Orchard Cottage  
4 Orchard Close  
Cuffley  
Potters Bar  
Herts

Re: Planning application to 5 Orchard Close Cuffley

3802/16.6/12

ADDRESS : 5 ORCHARD CLOSE, EN6 4QD	
PROJECT TITLE : EXTENSIONS AND LOFT	
DRAWING TITLE : PROPOSED	
drawn MIDAS PLANNING	scale 1 / 100 @ A3
date JULY 2012	dwg no. 378/03

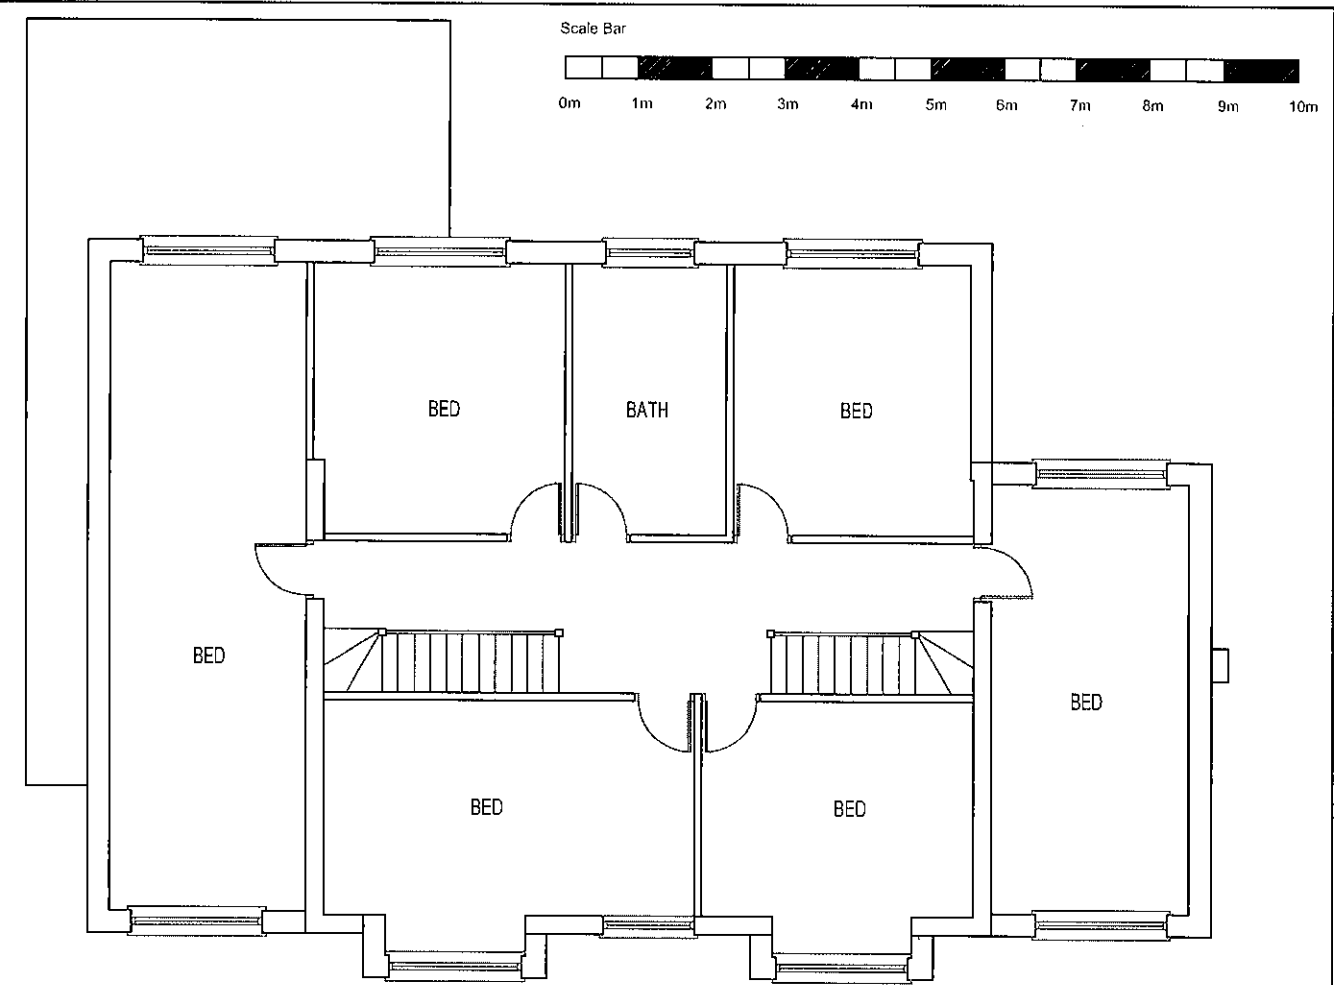
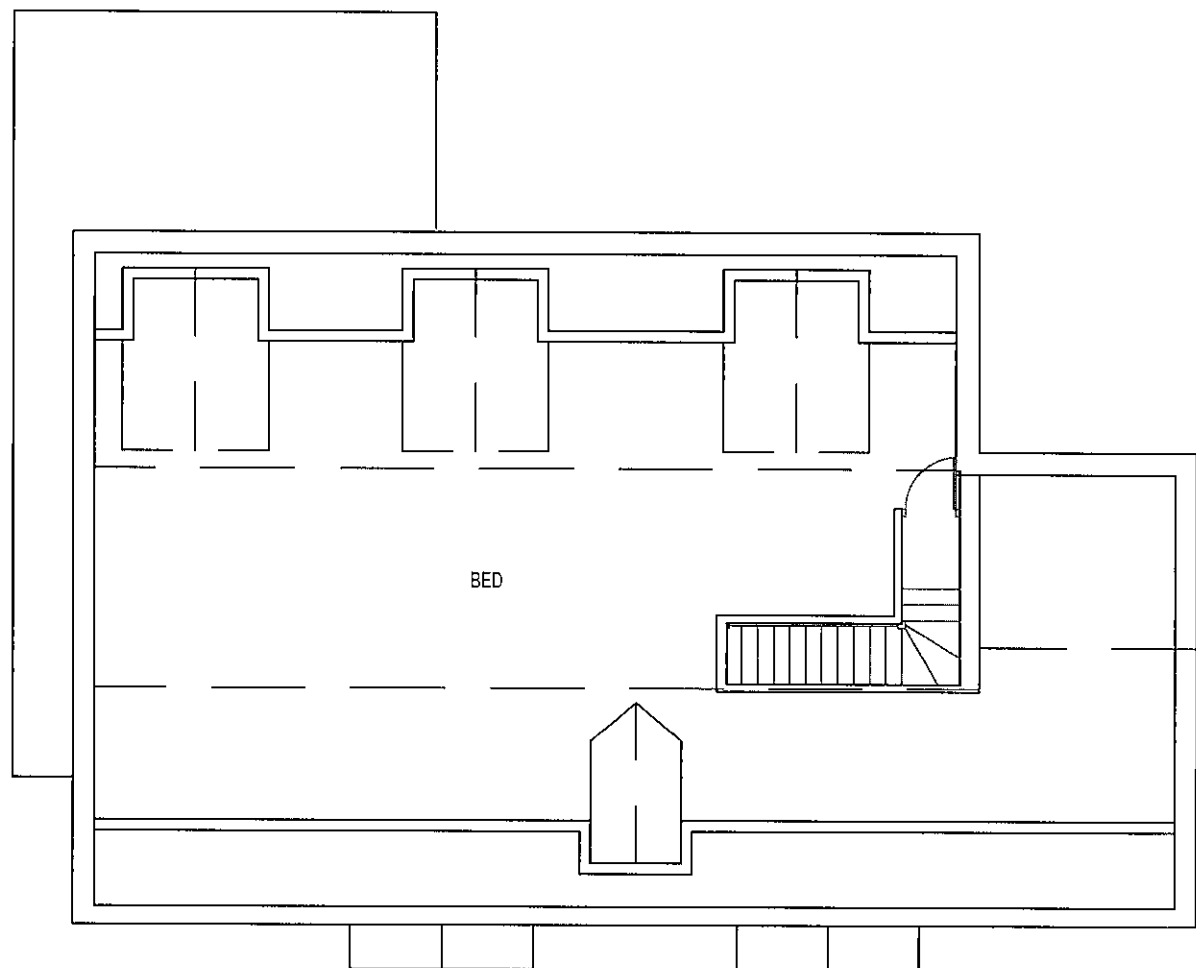
Finally I must mention that the available parking space on the proposal appears inadequate. A property of this size, six noted bedrooms plus the second floor would normally generate a significant number of cars. Off site parking would create problems within our small community.

ADDRESS : 5 ORCHARD CLOSE, EN6 4QD	
PROJECT TITLE : EXTENSIONS AND LOFT	
DRAWING TITLE : SITE PLAN	
drawn MIDAS PLANNING	scale 1 / 200 @ A3
date OCT 2013	dwg no. 378/05

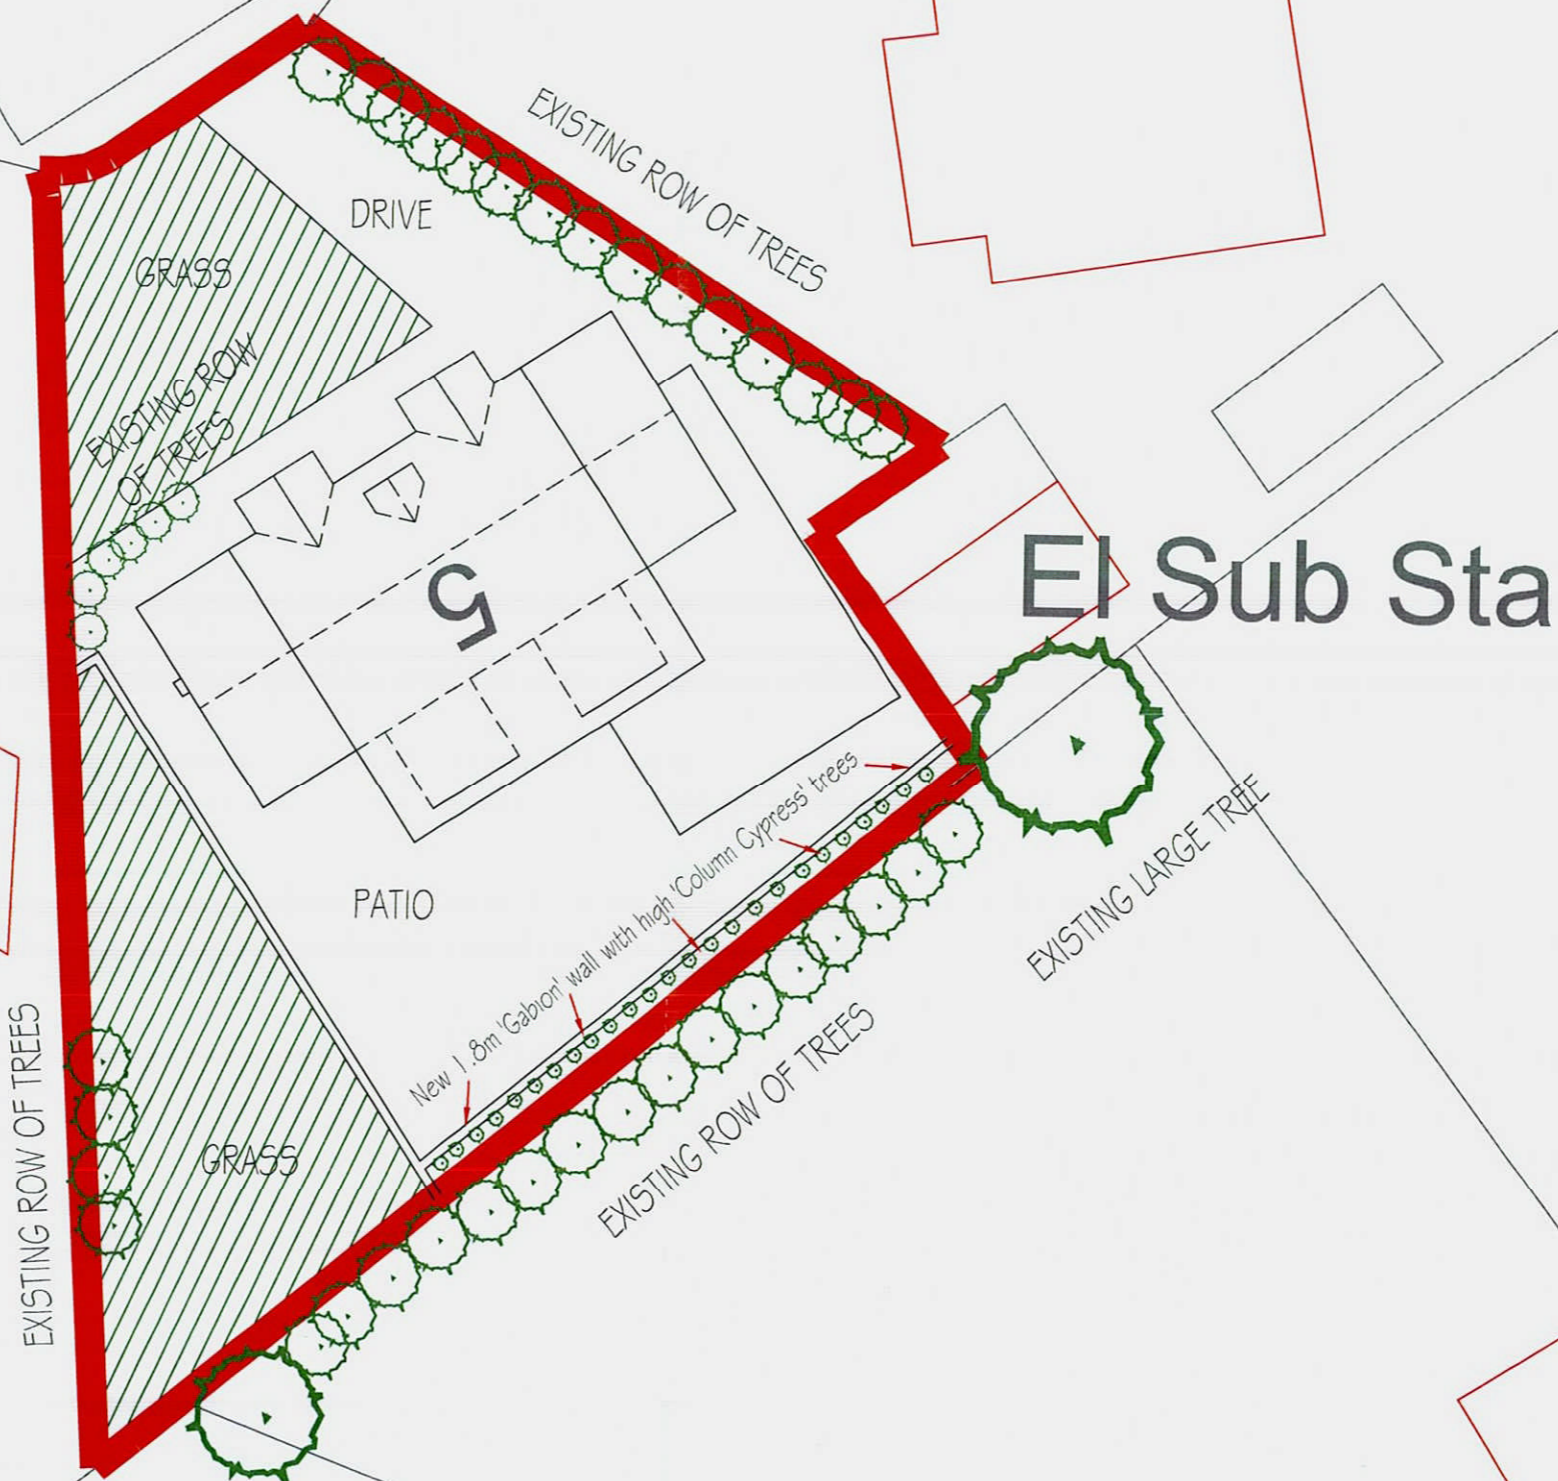
It appears the site plan 378 LO has an incorrect boundary. The site boundary between the subject property and number four is incorrect.
